**To: All Staff**  
**From: Environmental Health**  
**Date: 2/27/2026**  
**Subject: AU-26-00001 Deatherage - Notice of Decision and Appeal**

**DEATHERAGE SHORT PLAT
 PART OF SECTION 34, T. 18 N., R. 19 E., W.M.
 KITTITAS COUNTY, WASHINGTON**

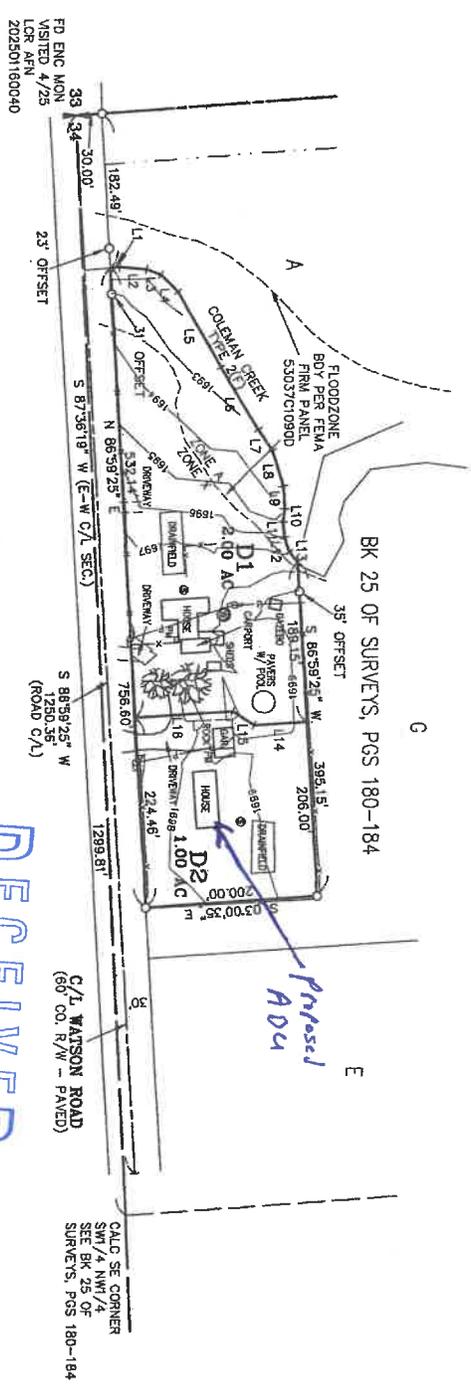
<b>Drinking Water</b>	<ul style="list-style-type: none"><li>• A shared well water users agreement form will be required.</li></ul>
<b>Wastewater</b>	<ul style="list-style-type: none"><li>• No comment.</li></ul>
